Tel: 01903 737756
Email: planning@arun.gov.uk
www.arun.gov.uk/planning
Please ask for: Mrs D Johnson
Email: daun.johnson@arun.gov.uk
Telephone: 01903 737762
Our Ref: P/124/25/PL
Your Ref:
Date: 29th September 2025

Application for Planning Permission

Development: 2 No single storey detached dwellings (with accommodation in the roof space) along with associated car and cycle parking (resubmission following P/9/24/PL). This application is a Departure from the Development Plan and is in CIL Zone 5 and is CIL Liable as new dwellings.

Location: Land To East Of Commonmead Barn Pagham Road Pagham PO21 3PY

Drawing Title:  
**PROPOSED ELEVATIONS AND SECTION  
 PLOT 1**

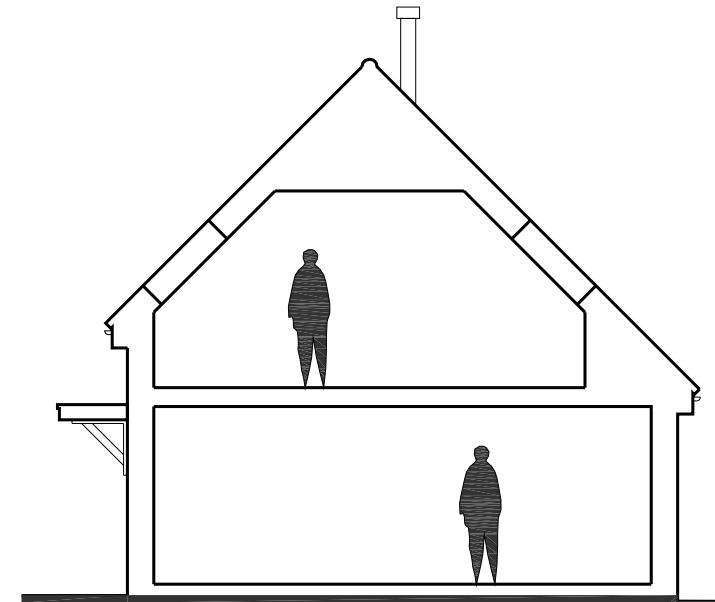
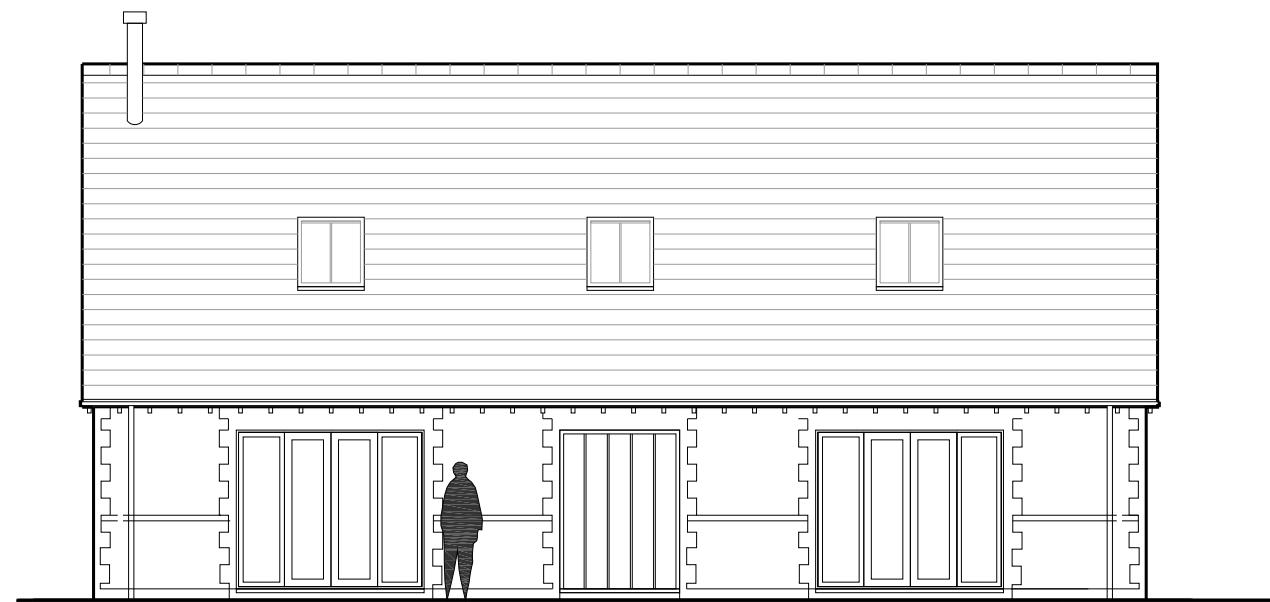
The south facing first floor plan and elevation window do not scale correctly. Please amend accordingly.

The north facing first floor plan and elevation window do not scale correctly. Please amend accordingly.
